## CONSULTEE RESPONSE (Arun District Council - Arboriculturist)

Reference: BE/16/25/RES

Proposal: Approval of reserved matters following outline consent BE/150/22/OUT comprising of 3no. units within Class B2 and/or B8 of the Use Classes Order (including ancillary office provision) with associated enabling works, parking, landscaping and sustainable drainage system with access off Newlands Road. This application is in CIL Zone 4 (Zero Rated) as other development.

Location: Land at Oldlands Farm, Newlands Road, Bognor Regis, PO22 9NN

DRAINAGE STRATEGY IMPORTANT NOTES

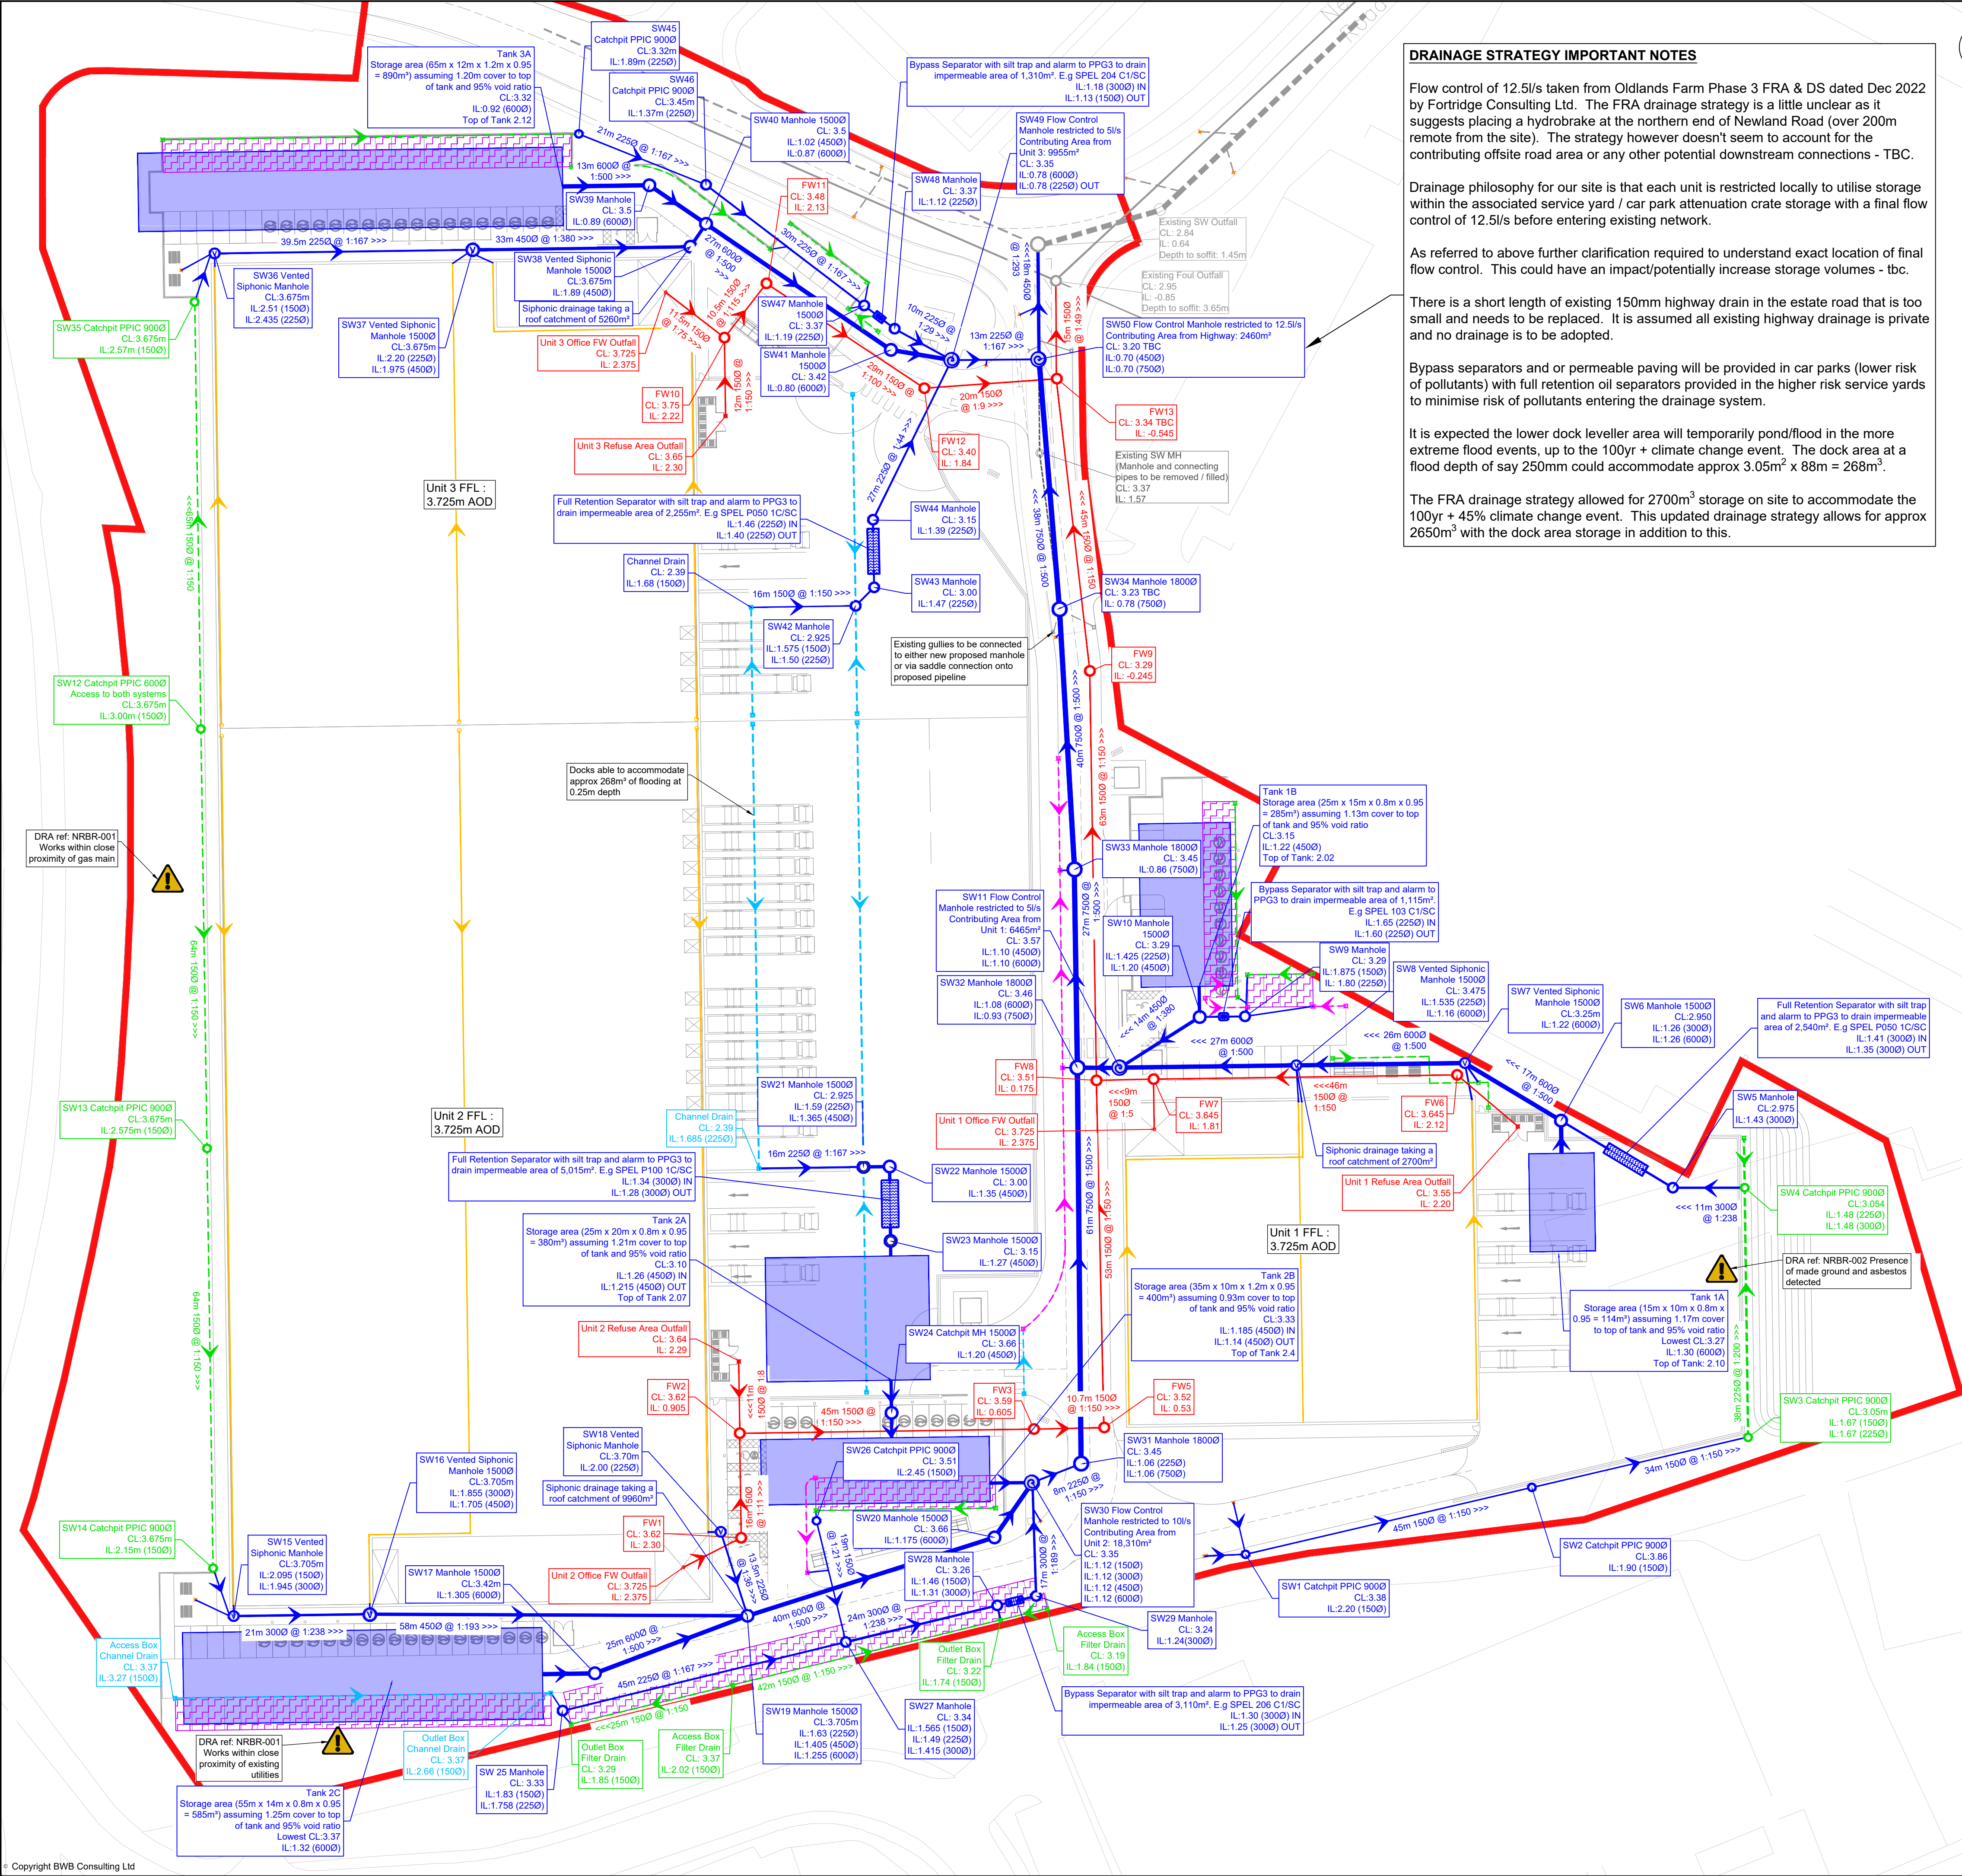
There does not appear to be an approved surface water drainage (and foul water sewer) strategy for the site. This fundamental element of the design ought to be addressed to our satisfaction in association with layout proposals, so that we are not subsequently held hostage to flood mitigation measures which could then impact heavily on retained trees/landscape plans.

The surface and foul water drainage layout reveals multiple areas of potential conflict between proposed utility apparatus and existing vegetation.

I draw attention to the nominal root protection areas (RPA) of retained trees and their growth potential as obvious constraints to the siting of any SUDS feature, soakaway or introduction of subterranean utility apparatus. The provision of appropriate buffer/easement around such features must also take into account that growth potential (roots), to limit the risk of damage occurring during future maintenance of the same, from compaction/contamination of the soil structure.

Notwithstanding my earlier stated concern for the absence of an approved surface water drainage strategy, I see no reason to object to this scheme directly on arboricultural grounds.
